THAKEHAM

1st March 2022

Re: Land North of Lee's Yard, Woodgate – AL/141/21/RES

I am writing in relation to the submitted Reserved Matters application (Ref: AL/141/21/RES) at Land North of Lee's Yard, Woodgate and the comments received on the 11th January 2022 from your Drainage engineer, Laura Gibbons.

Drawing Status	PLANNING
Client	Southern Home Ownership & Thakeham Partnerships Ltd
Project	Land North of Lee's Yard, Lidsey Road, Woodgate, PO20 3SU
Drawing Title	Site Location Plan
Scale	1:2000
Date	Nov '21
Drawn By	MJA
Checked By	MJA
Drawing No.	D2019-PL100
Rev.	-

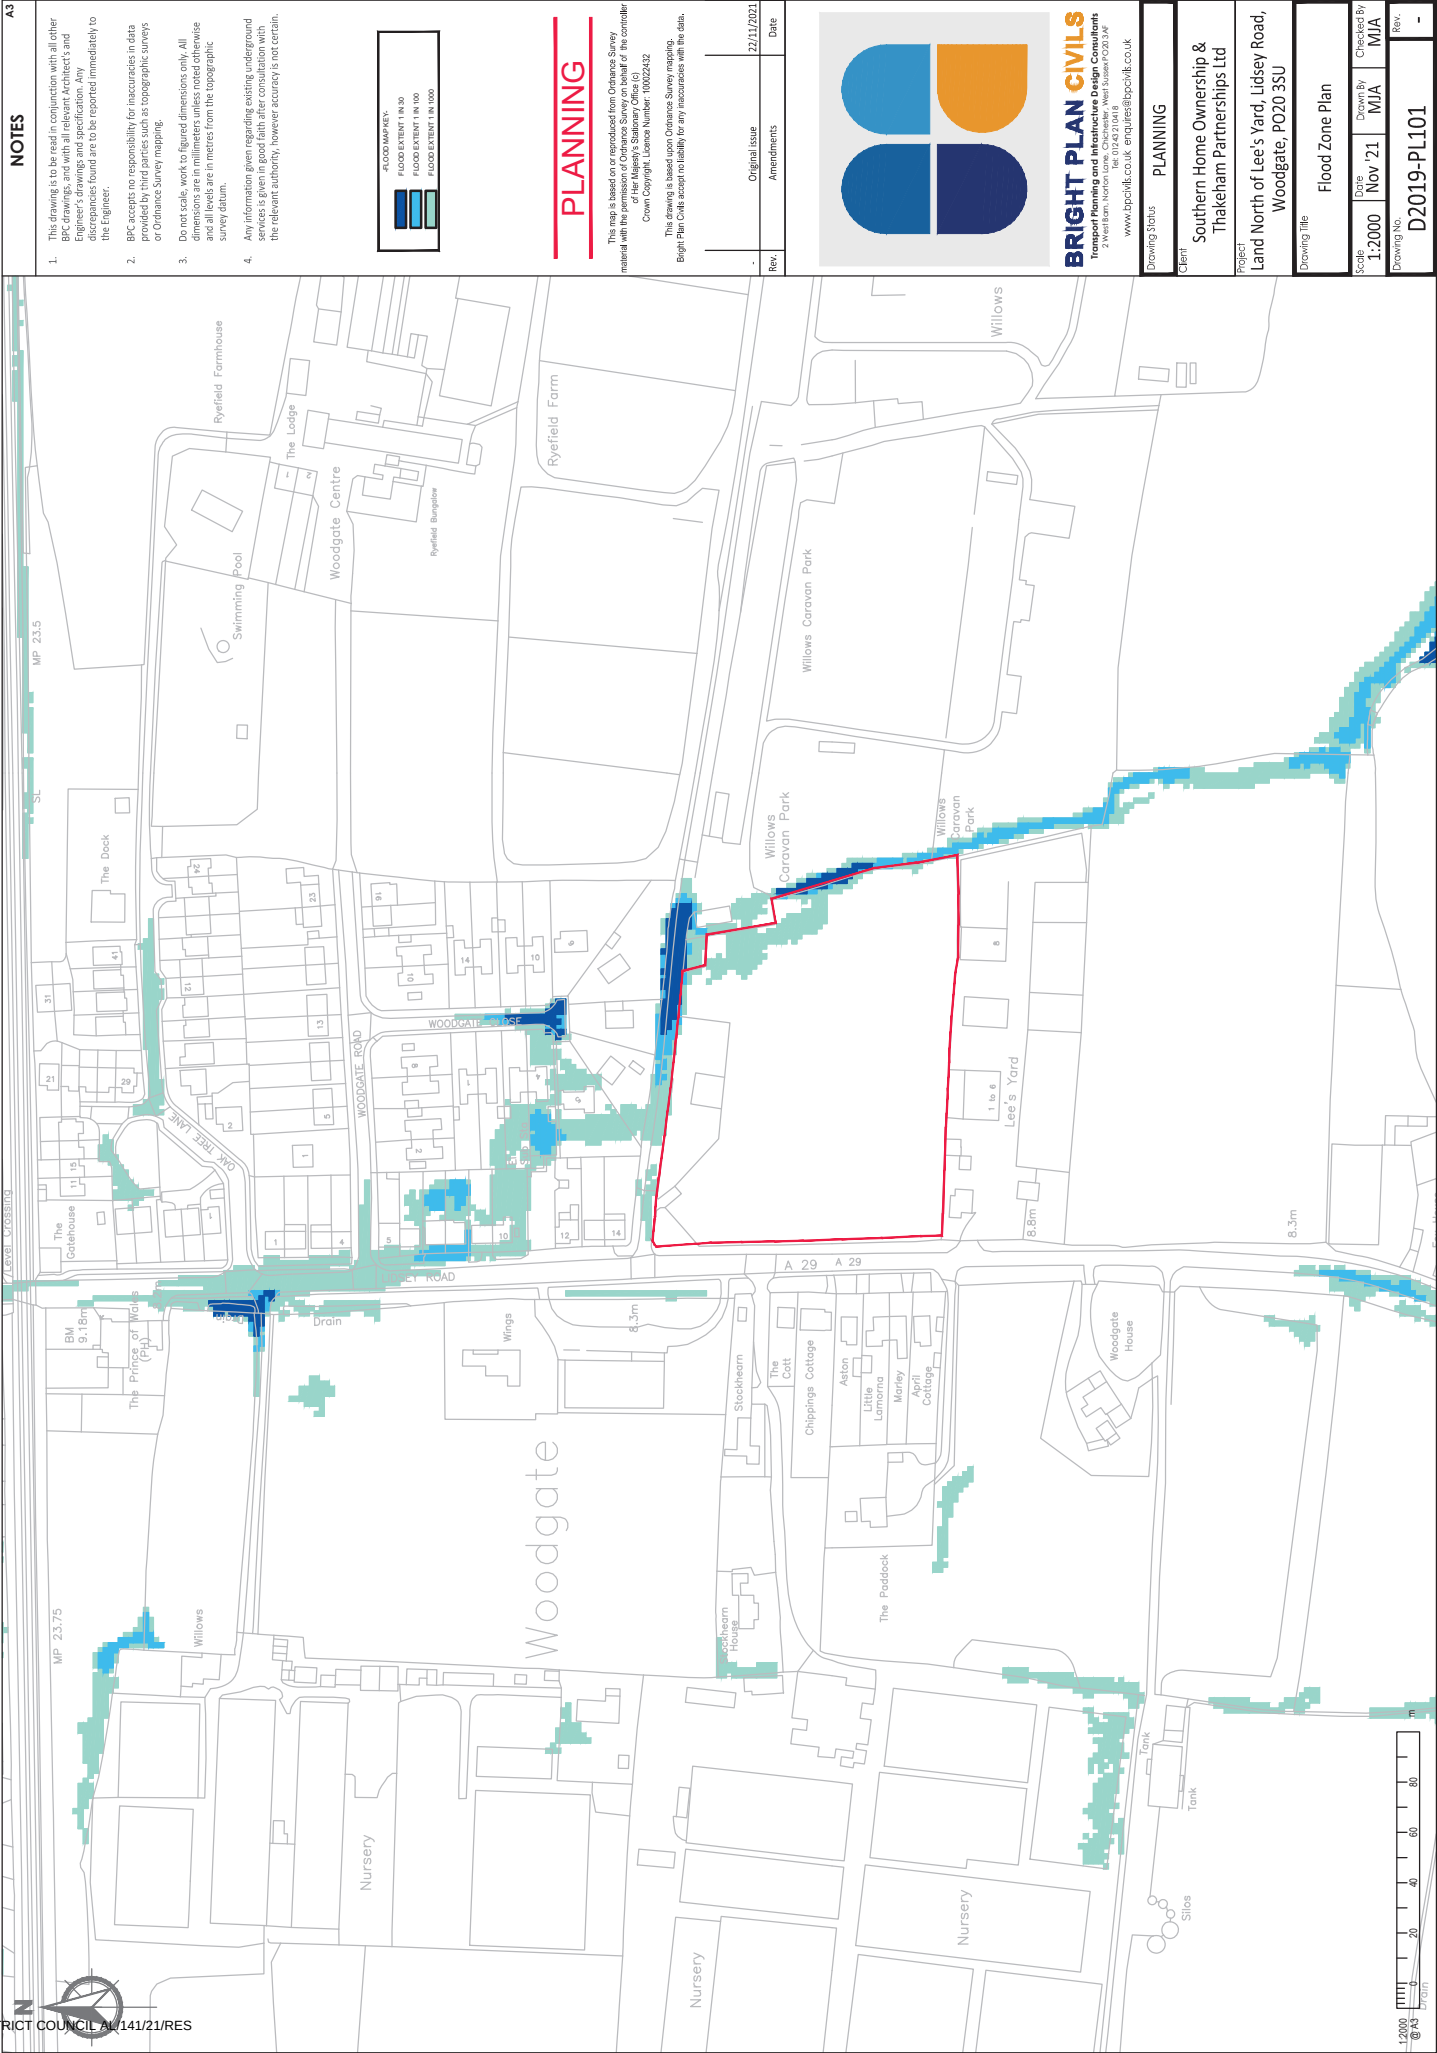
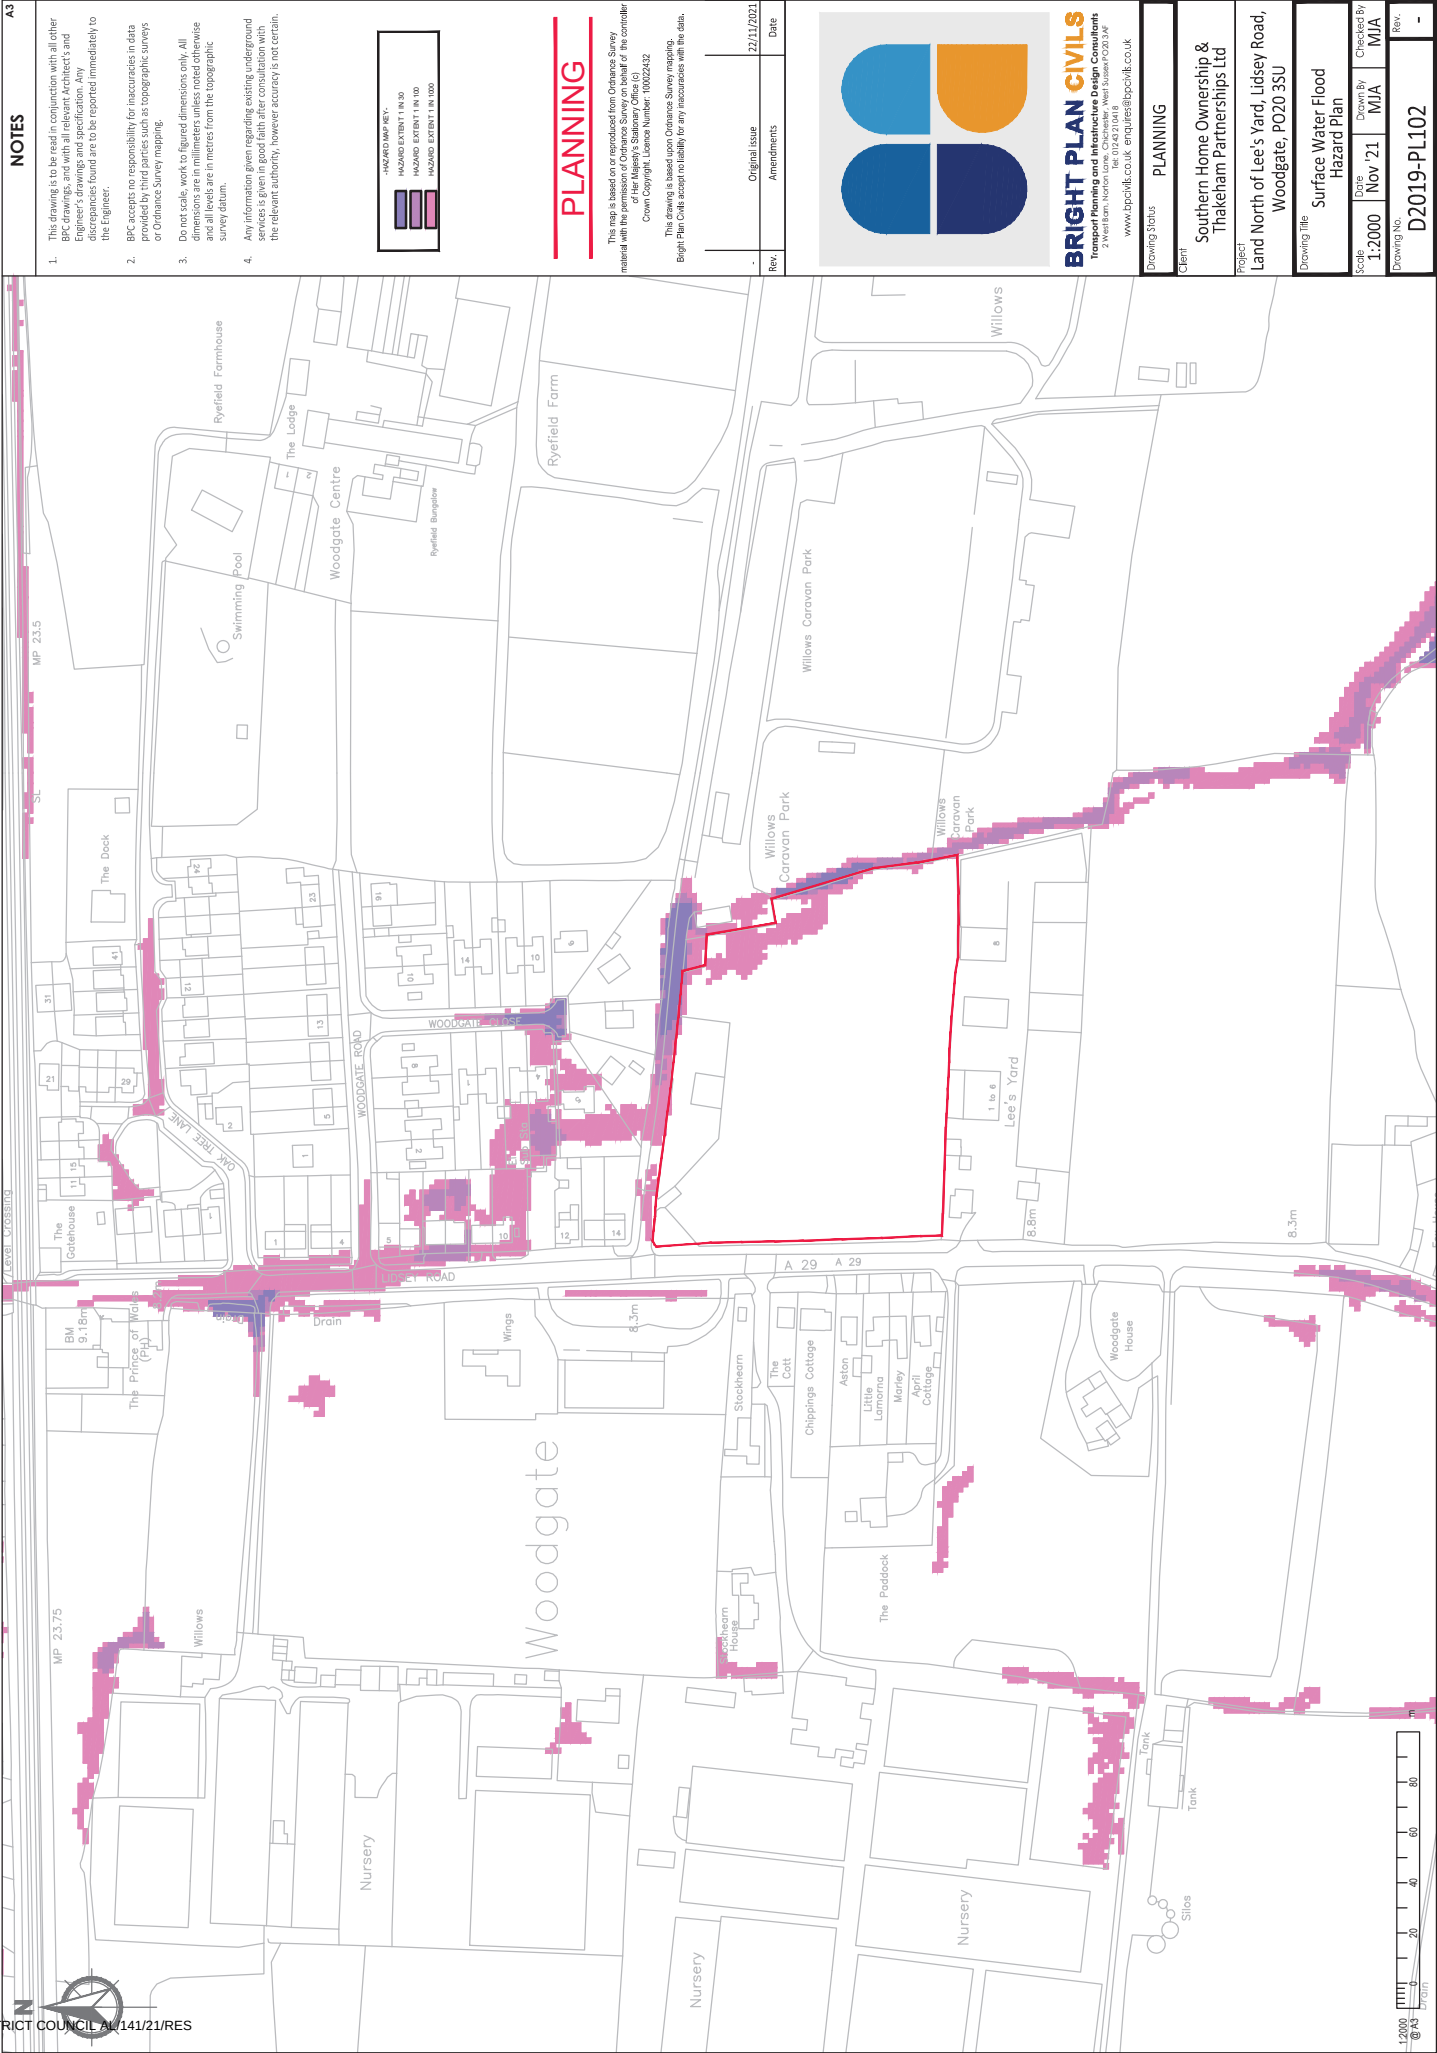
Drainage Engineer Comment: *The proposed attenuation basin is proposed within very close proximity of the watercourse. The basin must be located a minimum of 3m from ordinary watercourse. The location of existing trees should also be carefully considered with basin design. The basin is proposed to be bunded above surrounding ground level, this will result in water being held above surrounding ground level. Water should be retained below existing ground level as much as possible to remove the risk of breach.*

1. *Please adjust the basin position to ensure a minimum of 3m between the top of bank of watercourse and toe of retaining bund.*

2. *Please adjust the basin position to ensure a minimum of 3m between the toe of bund of the detention basin and existing tree root areas.*

3. *Please adjust the basin size to ensure that 300mm of freeboard is provided above peak anticipated water level.*

4. *Please adjust the basin so that it is set lower in the ground.*

5. *Please supply details of the improvements that will be completed to the ordinary watercourse.*

Response: The SW basin location, shape and elevation have been revised in coordination with the project Arboriculturist. This now clarifies this also complies with a 3m buffer between the top of bank (watercourse) and top of bank (SW Basin).

Response: As discussed with Ms Gibbons, we have aligned this buffer to be top of bank (watercourse) and top of bank (SW Basin). This can therefore be conditioned accordingly as the two features can share the 3.0m buffer.

Response: This has been reviewed and coordinated with our Arb consultant and the RPZ areas are now shown on the drainage plan. The basin footprint (to top of bank) has been adjusted and shifted back slightly to be clear of the RPZ. We are permitted to locally batter down slightly within these areas noting the tree boles are set back.

Response: The 24hr half drain down times have been reviewed against the current flow controlled rated of 2.0l/sec so we can consider if the flow rate (currently pro-rata QBAR) is too low. The calculations have also been expanded to demonstrate a wider selection of return periods to observe the peak water levels/freeboard within the SW basin. Firstly please note the 'inflow' figures are a 'rolling figure' due to the dynamic hydraulic analysis, however the SW basin node should still be reporting a similar figure here for the 24hr period as below:

Response: Whilst the groundwater levels are observed to be shallow, the proposed SW basin has been lowered slightly which also slightly improves the surrounding tie-ins.

Response: An Additional annotation is now shown. This allows for the lower section of the watercourse to be cleared of debris/siltation and locally re-graded so the base and top of banks will be re-worked to ensure this blends with the SW basin with a minimum 1:4 maintenance slope.
